# GREATER LONDON AUTHORITY

## Deadline 3 - GLA Sheet 1: Applicant's Response to GLA Relevant Representations

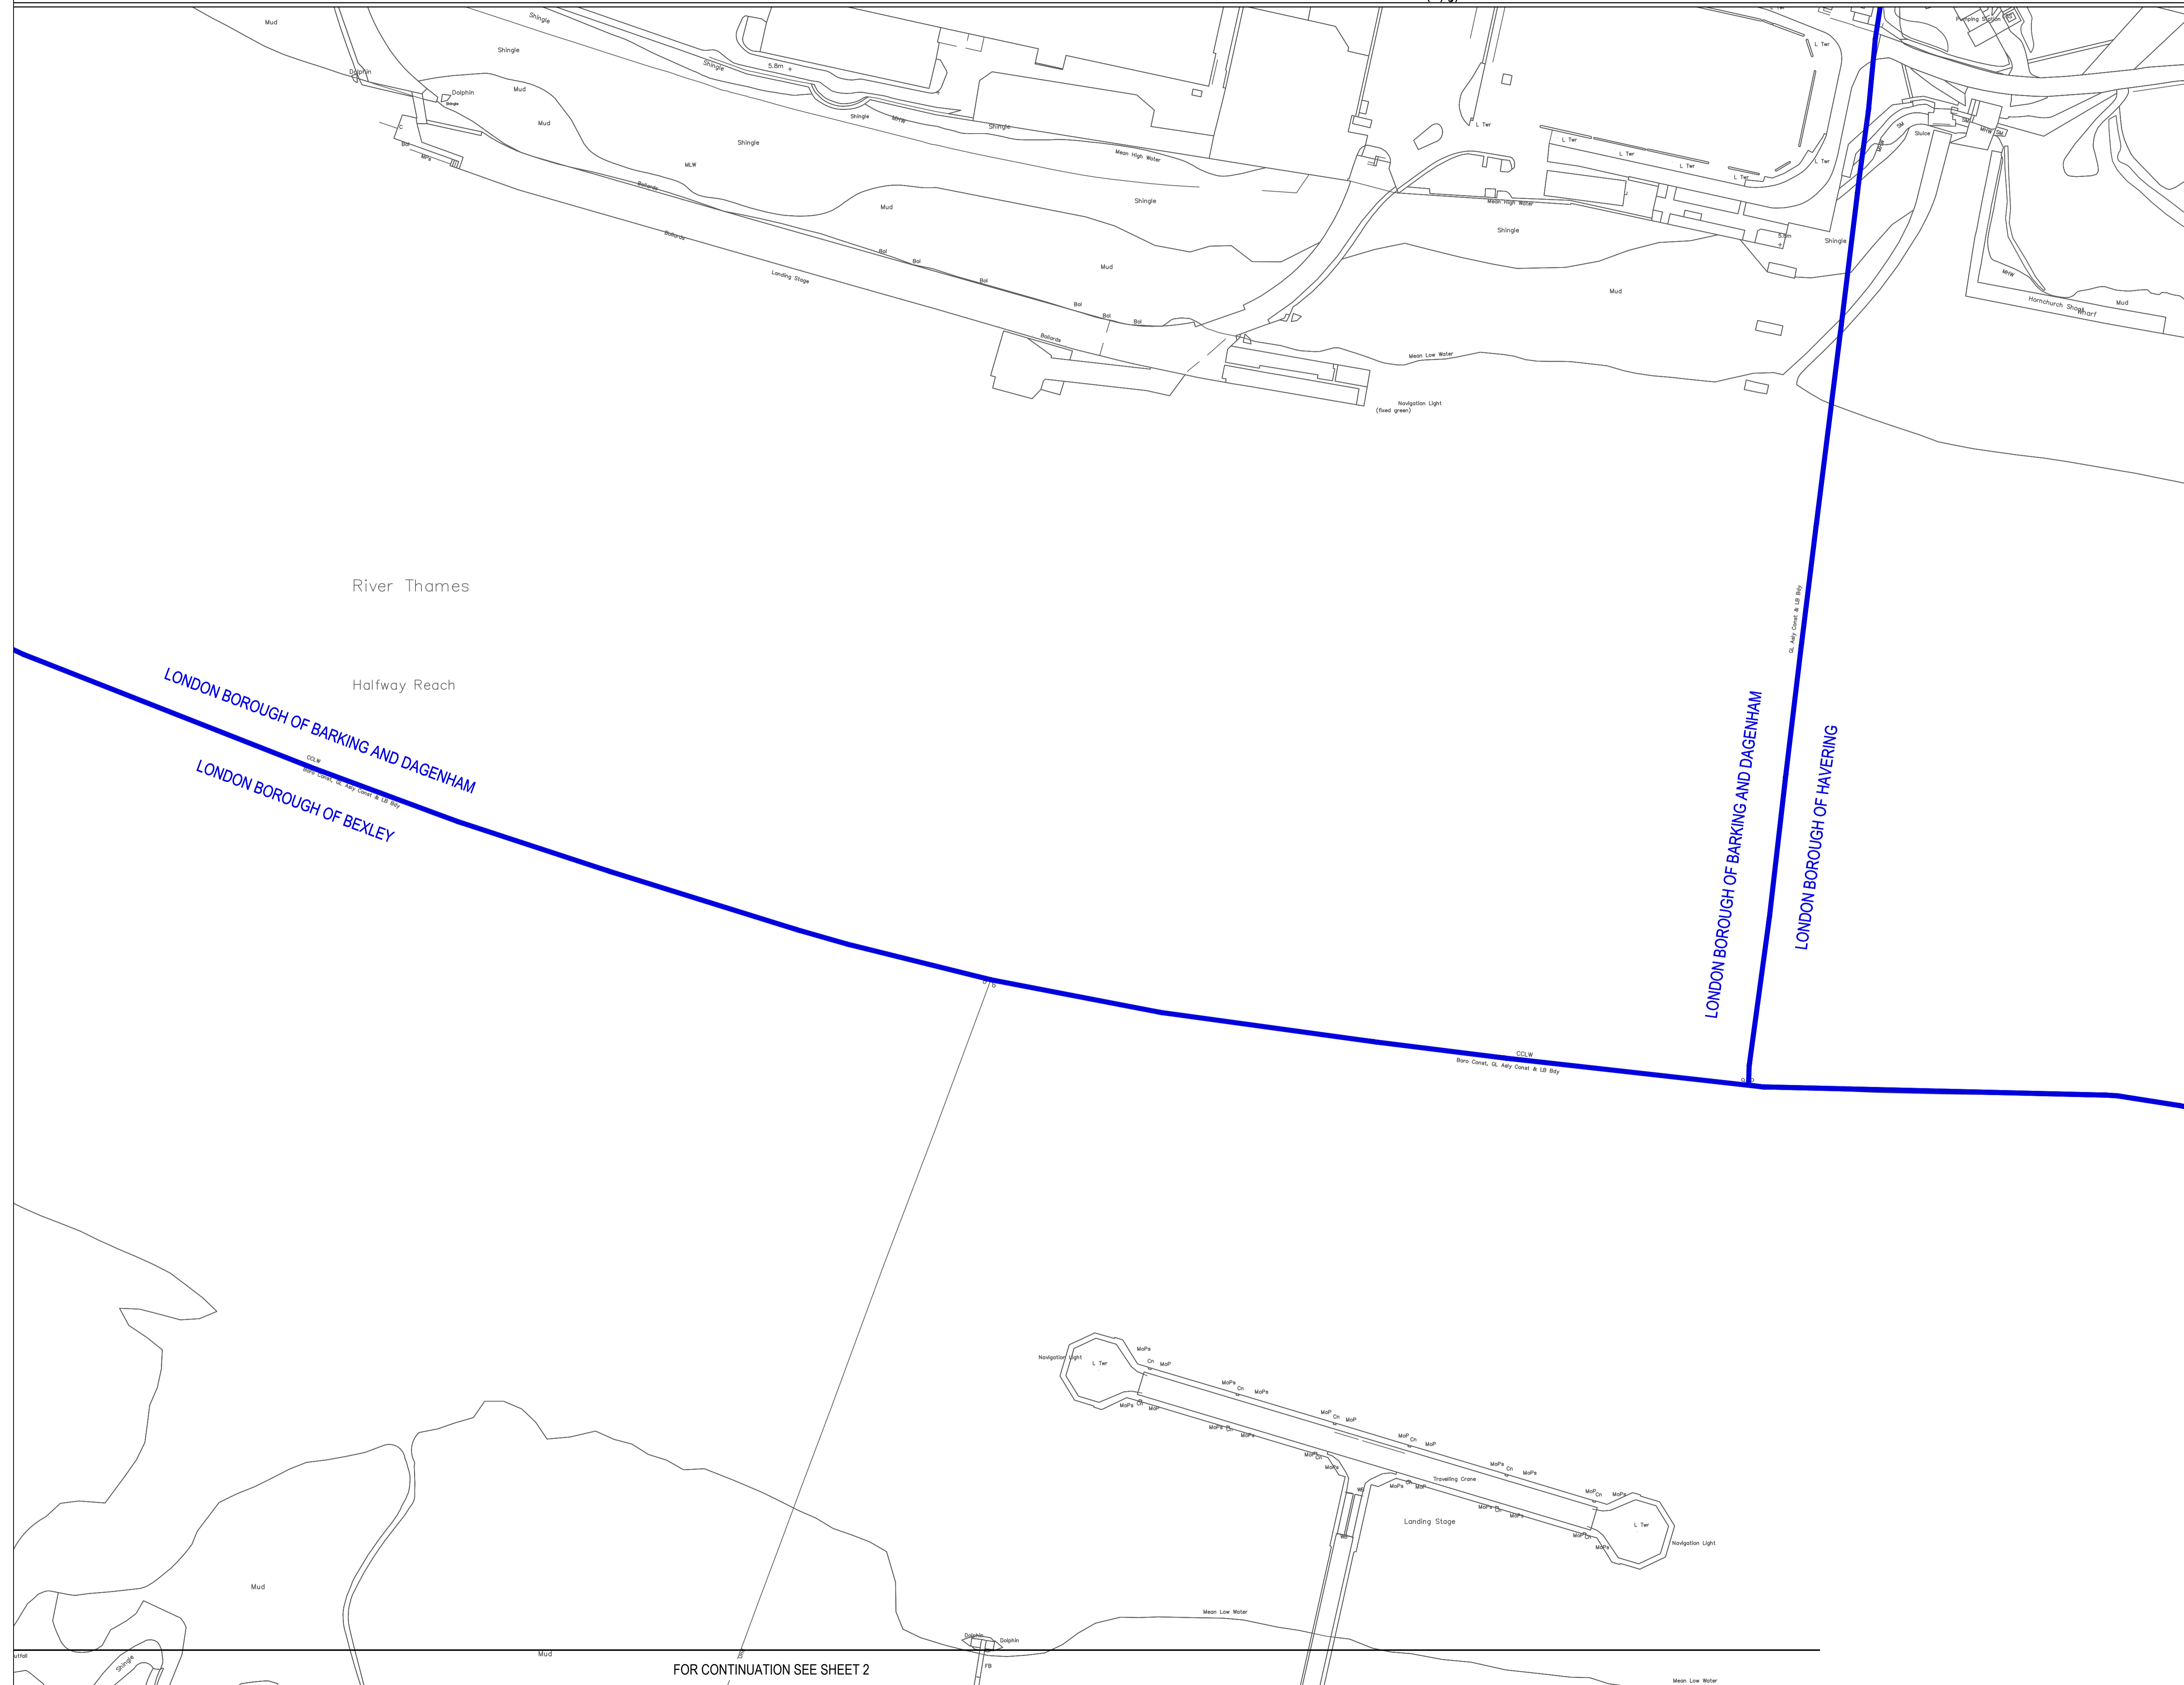
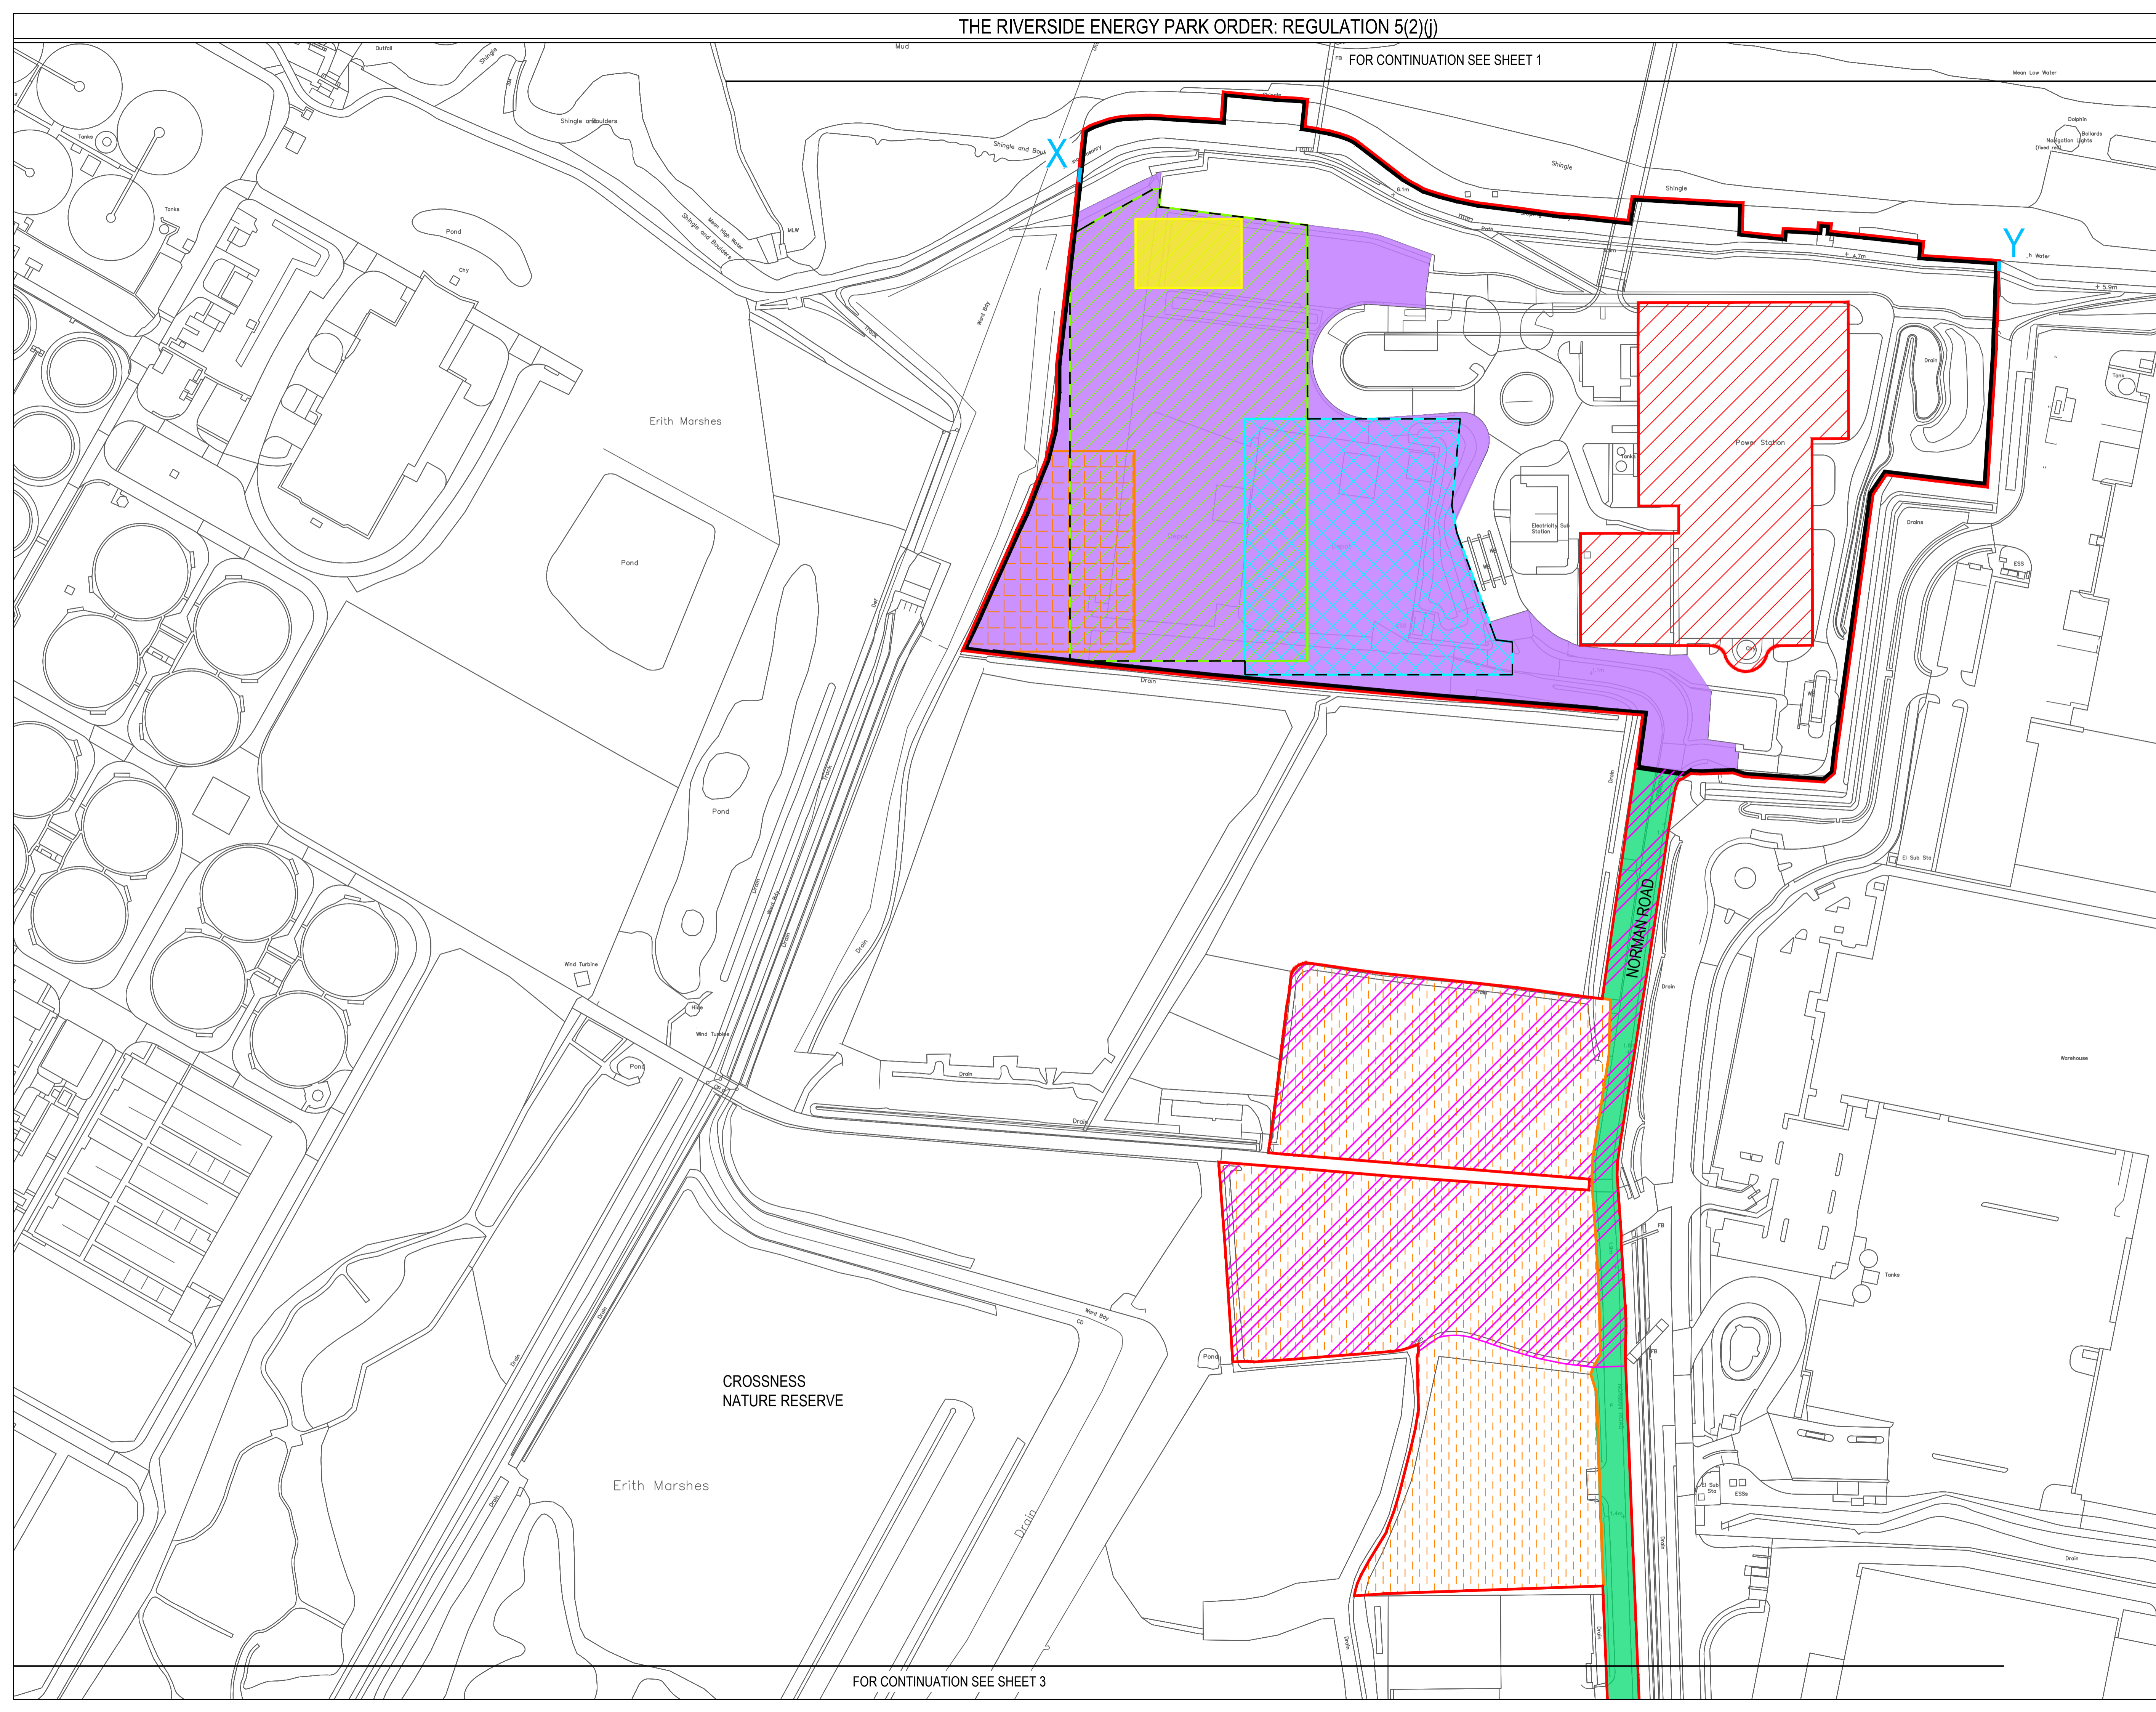
Issue	Applicant's comment	GLA/TFL Comment / action
	<p>in 2018 with the ambition of establishing a collective approach to the development of a heat network in the locality. The Applicant has expressed its intention to supply renewable/low carbon heat for residents and commercial developments through the provision of a low temperature heat network.</p>	
<p><b>Air Quality</b></p>	<p>2.5.32 The GLA states that the geographical scope and magnitude of the impacts on air quality is not in accordance with the London Plan or the draft London Plan air quality policies. The Applicant is uncertain what is meant by this.</p>	<p>This is further explained within the GLA's LIR and WR, submitted for Deadline 2.</p>
	<p>2.5.36 As detailed in the Environmental Permit and Air Quality Note (8.02.06), submitted for Deadline 2, the Applicant is proposing the installation of the NOx abatement technology of Selective Catalytic Reduction (SCR). The proposed SCR will result in significantly lower NOx emissions than were applied in the air quality assessment reported in Chapter 7 Air Quality of the ES (6.1, Rev 1).</p>	<p>The Industrial Emissions Directive does not allow for permits to specify the technology that is used to achieve specific emission limits, so the use of SCR cannot be directly secured through the permit.</p> <p>The SCR is shown on the indicative process diagram for the permit application but there are no plans showing how it will be accommodated within the proposed building envelope. Both the current and draft BREF notes state that the space needed to install and maintain SCR are significant constraints on their use as BAT. Without assurance that the unit can be accommodated on site it would therefore be open to the Applicant to argue at a later stage that it is not BAT, particularly if DCO requirements impose restrictions on the size and shape of the building. The Applicant should provide more detail on this point. As the provision of SCR has now formally been offered by the Applicant through its document 8.02.06 Environmental Permit and Air Quality, the Applicant should be asked to demonstrate how the SCR technology would be provided within its Works Plans.</p>
